Planning Application: Seeking advice on a planning application for this site for 9 new dwellings.

Reference: WA/75/17/PL

Location: Land adjacent to Sunny Corner, Copse Lane, Walberton

T24 BS Condition A

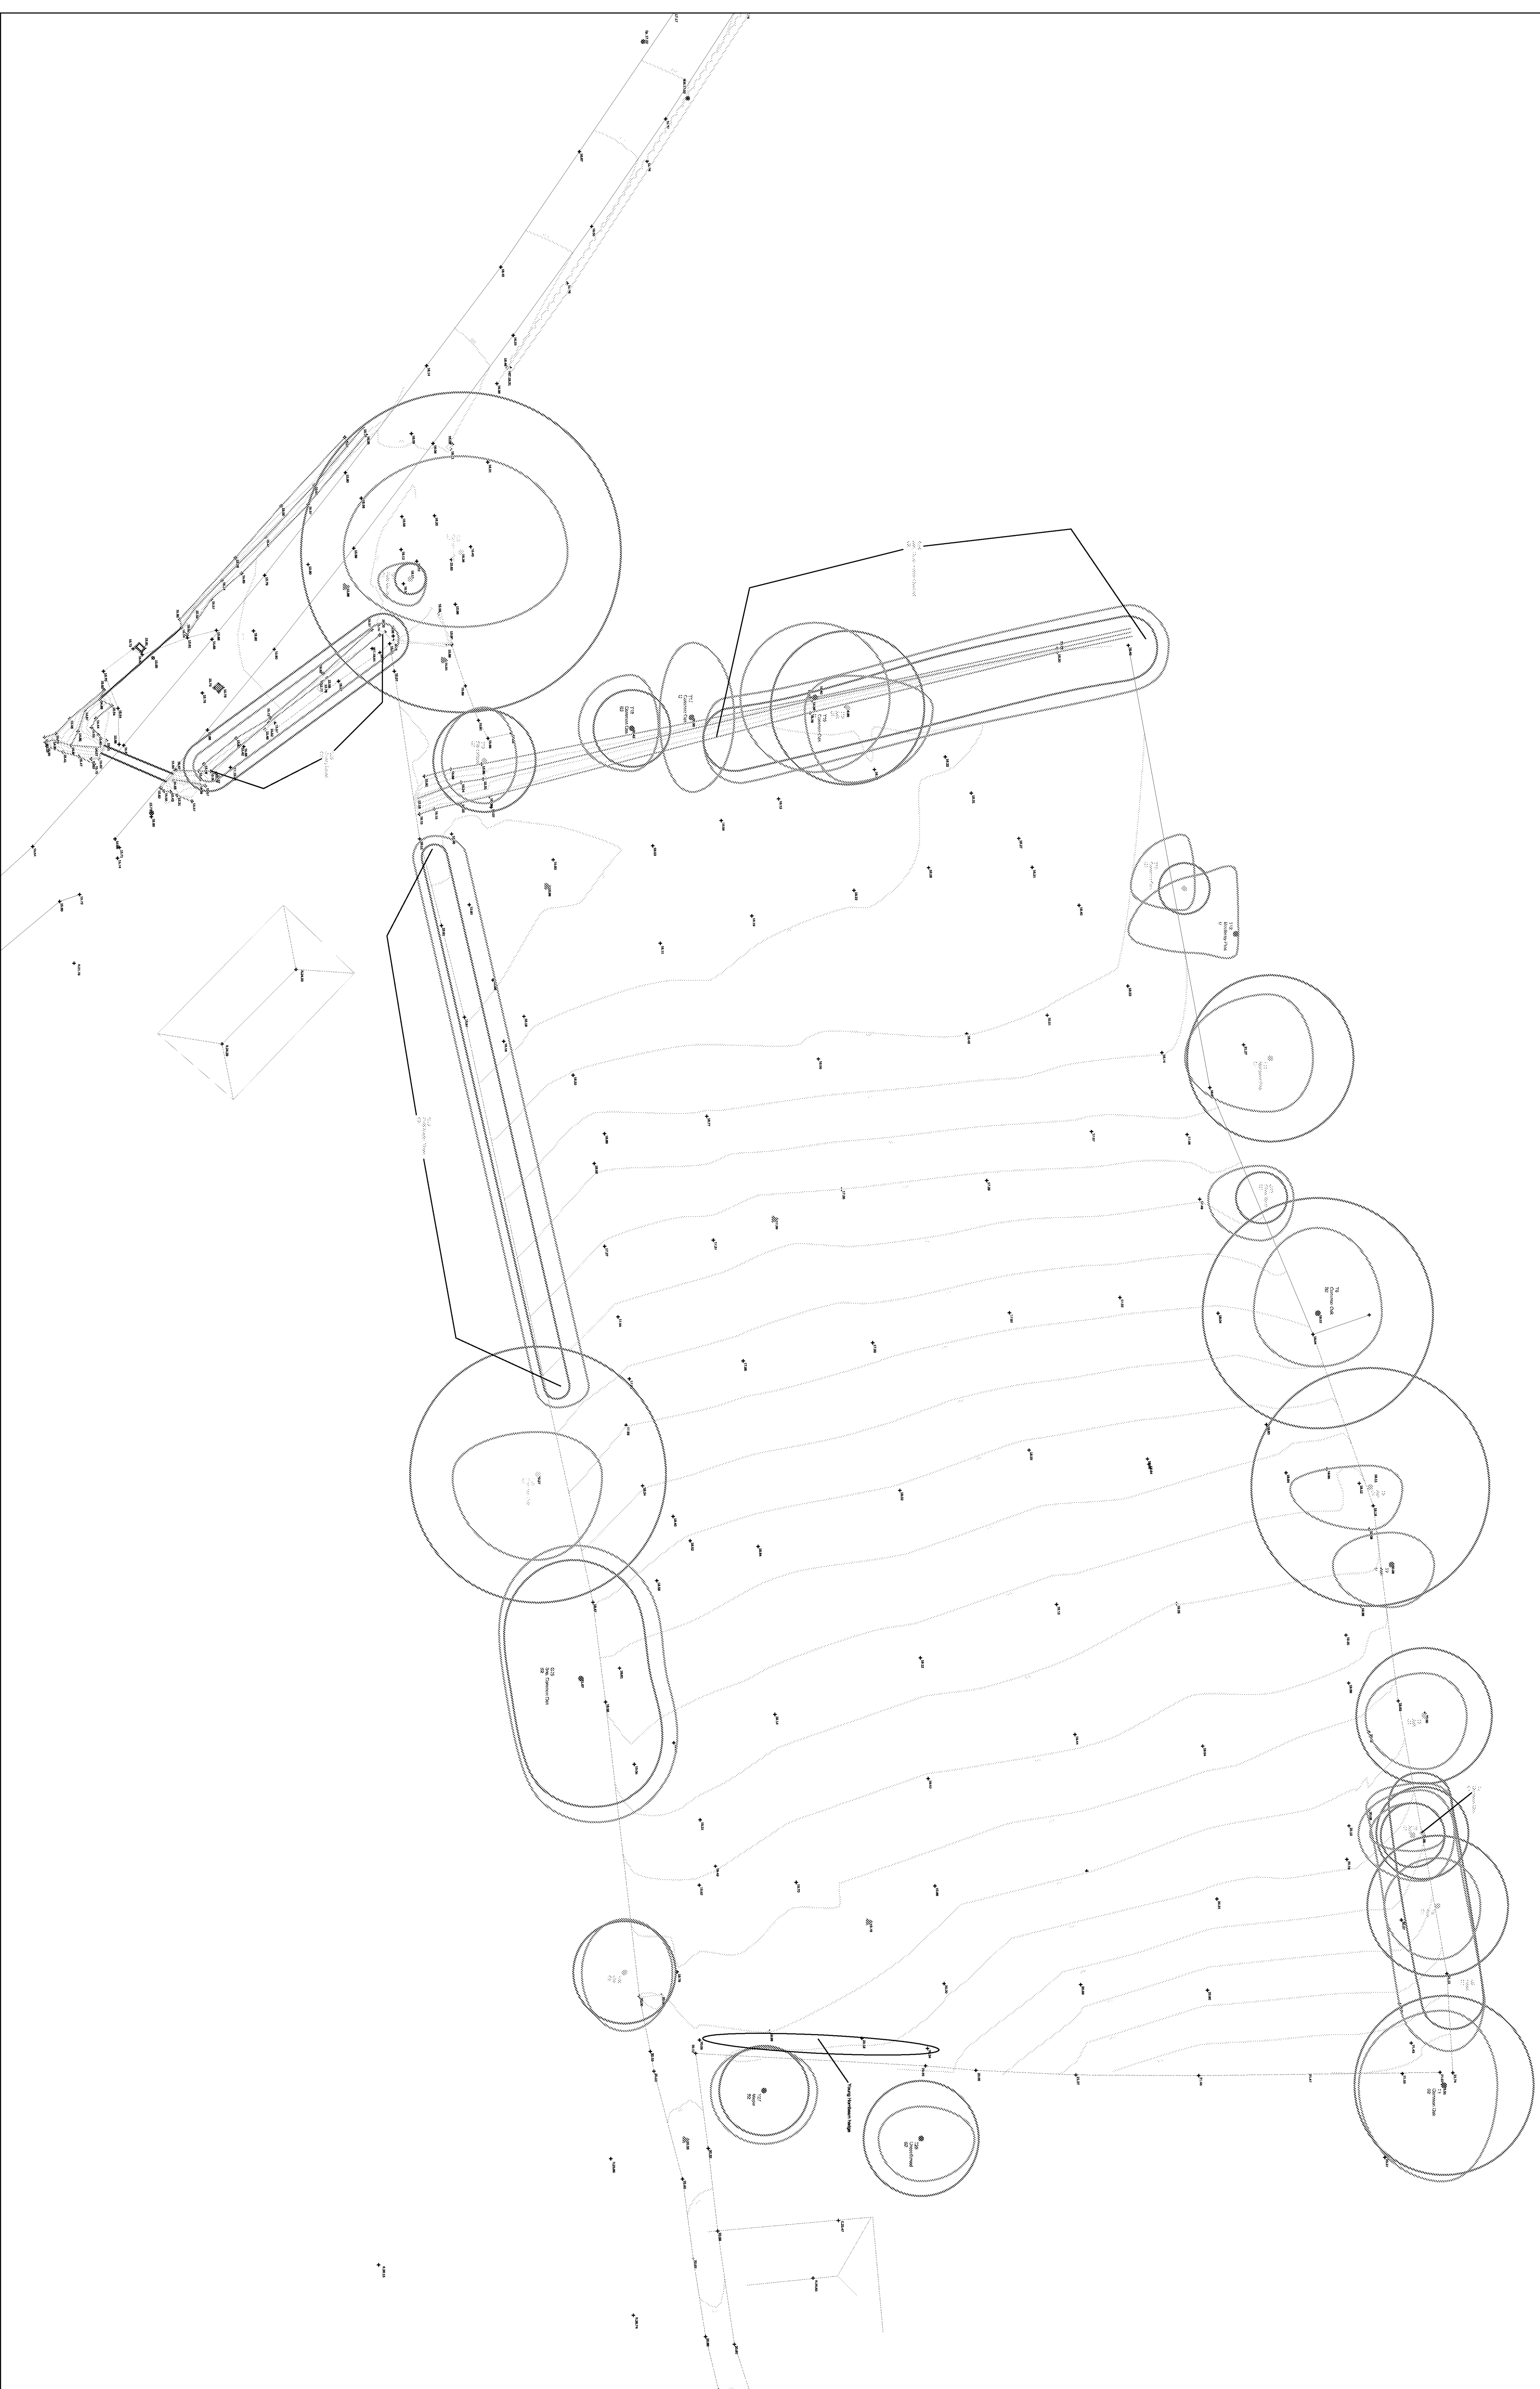
- The Tree Survey data is comprehensive and accords with the requirements of BS5837:2012.
- However the calculation of multi-stemmed trees does not - in that a 'so called' equivalent single stem diameter is quoted in place of the correct diameters of each stem being measured at 1.5m from ground and listed in the schedule and then the calculation methodology detailed in BS5837 applied to arrive at an RPA. Thus I have no way of checking if the RPA's quoted for the multi-stemmed trees are correct.

- Access to this site is proposed from Copse Lane - necessitating that two small Field Maple are removed (I have no issue with this) and a 'No Dig' Porous road is constructed to avoid root damage to the Oak T20. The layout proposed significantly impinges on the RPA for Oak T24.
-

- The overlap of the RPA of Oak T24 is unacceptable and I would wish to see a re-design that fully respects the RPA by staying outside of it with all new buildings. In the interim this tree is under threat and I recommend that a TPO is made to protect it.

- The accuracy of the tree root protection data submitted in support of this application cannot at this time be verified and further information on the diameters of the multi-stemmed trees will need to be submitted.
